CITY OF ALBUQUERQUE

June 4, 2008

Re: Sony Imageworks Grading and Drainage Plan
Engineer's Stamp dated 5-8-08 (R16/DA3006)

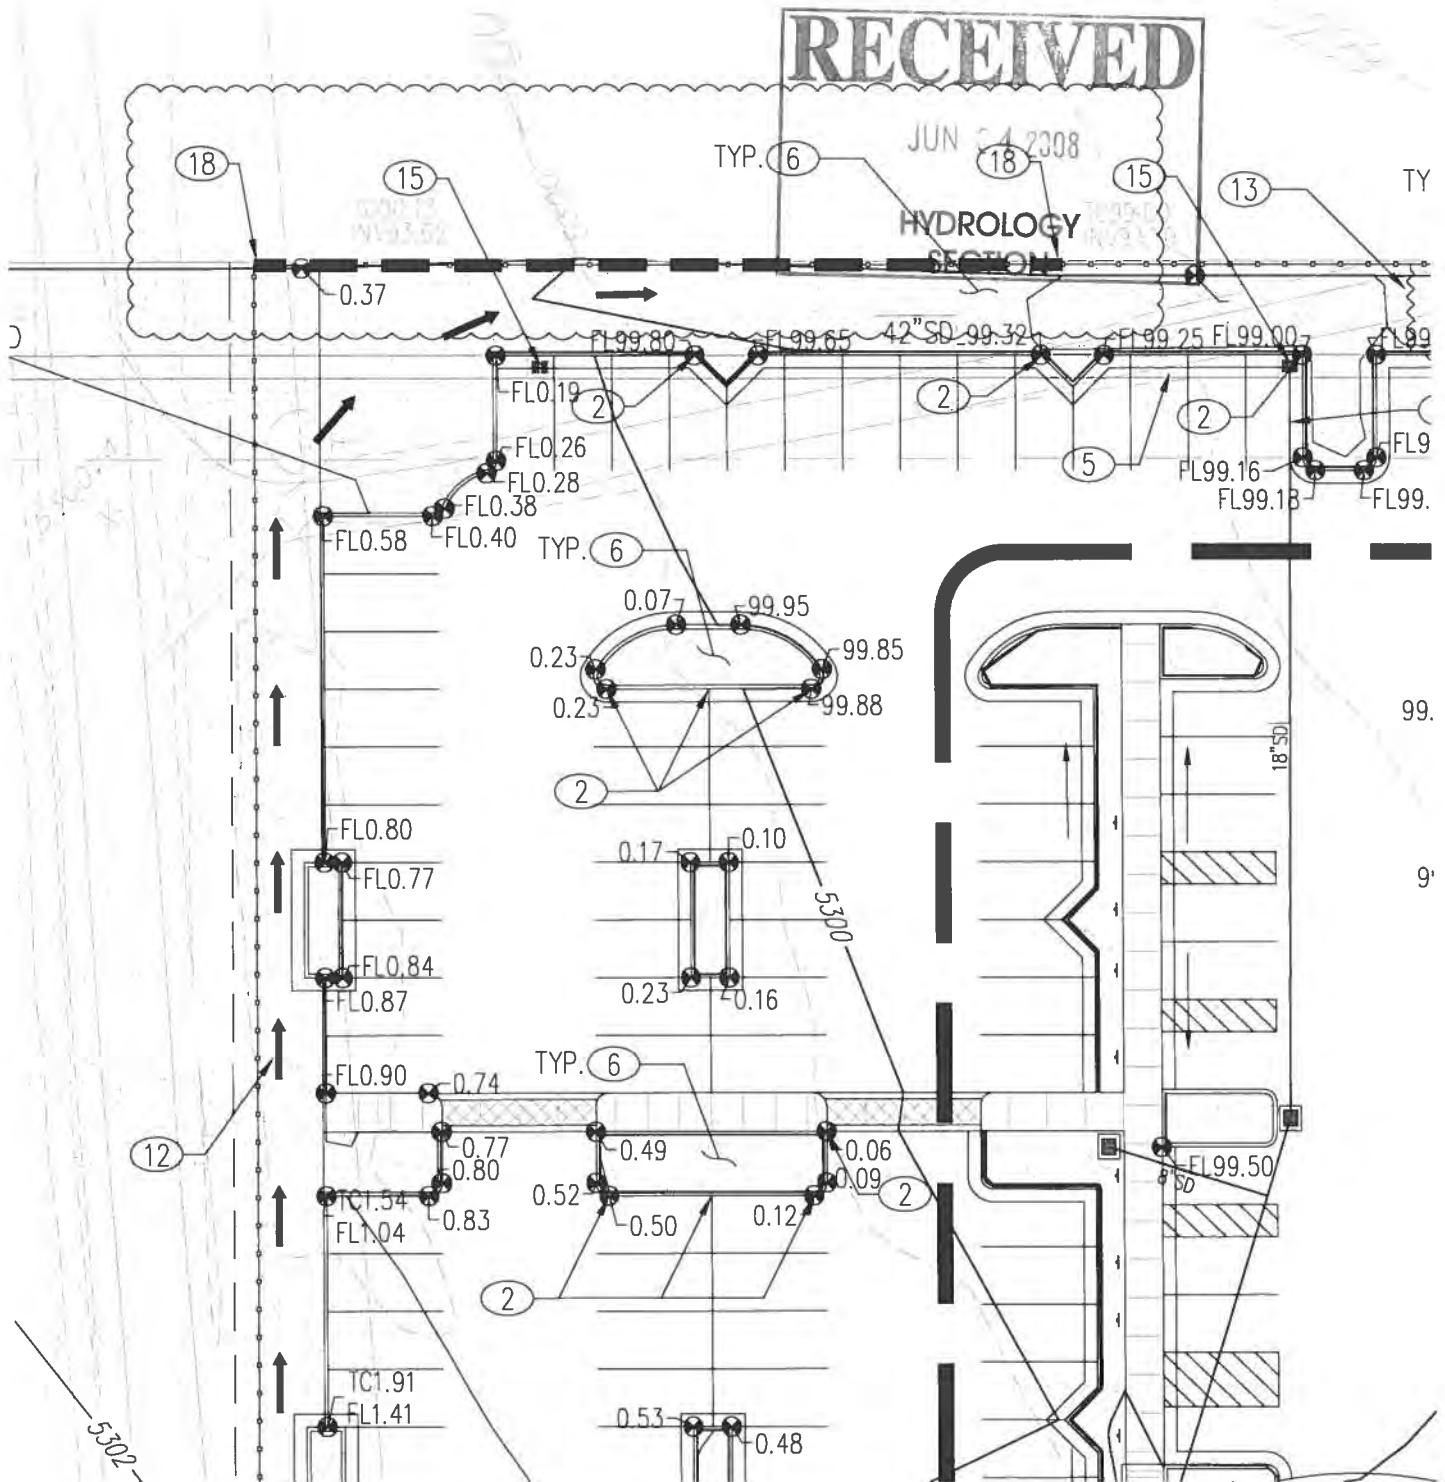
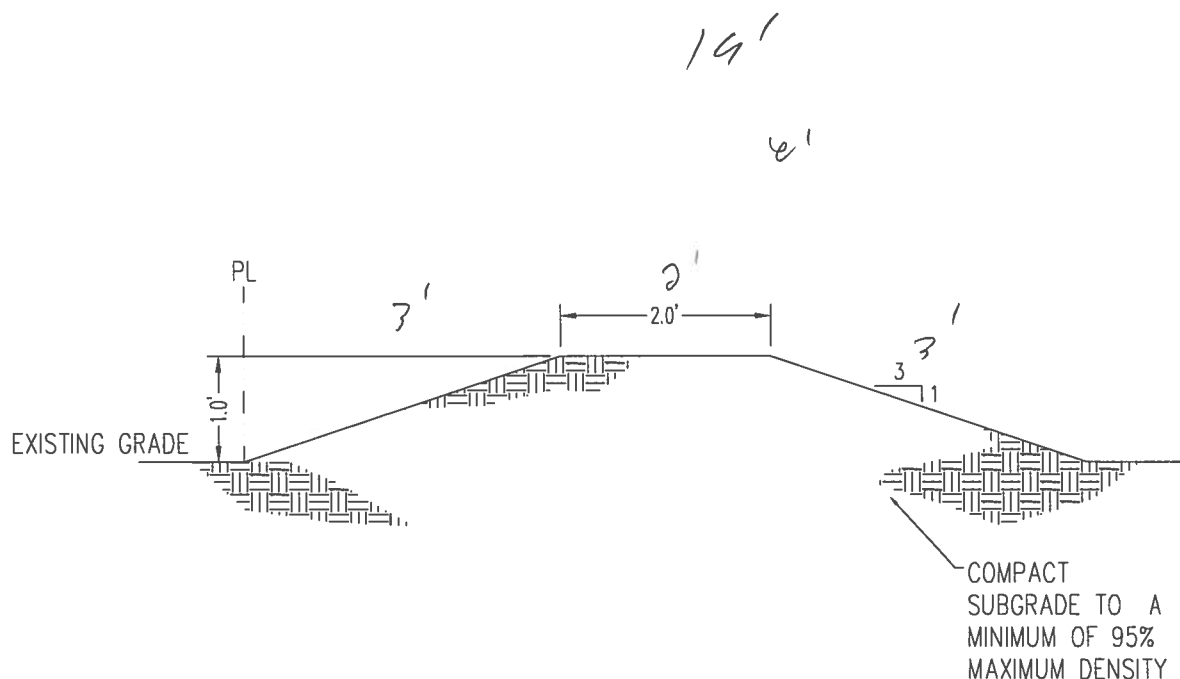
- Engineer Certification per the DPM checklist will be required.
- Include the berm and the berm detail, received 6-4-08, on the certified plan.
- Per the AHYMO data submitted 6-4-08, the max water surface elevation for the pond in Basin 3 is 5298.75. Update this on the certified plan.

With this letter, we have provided a detail of the drainage control berm that we will issue to the contractor.
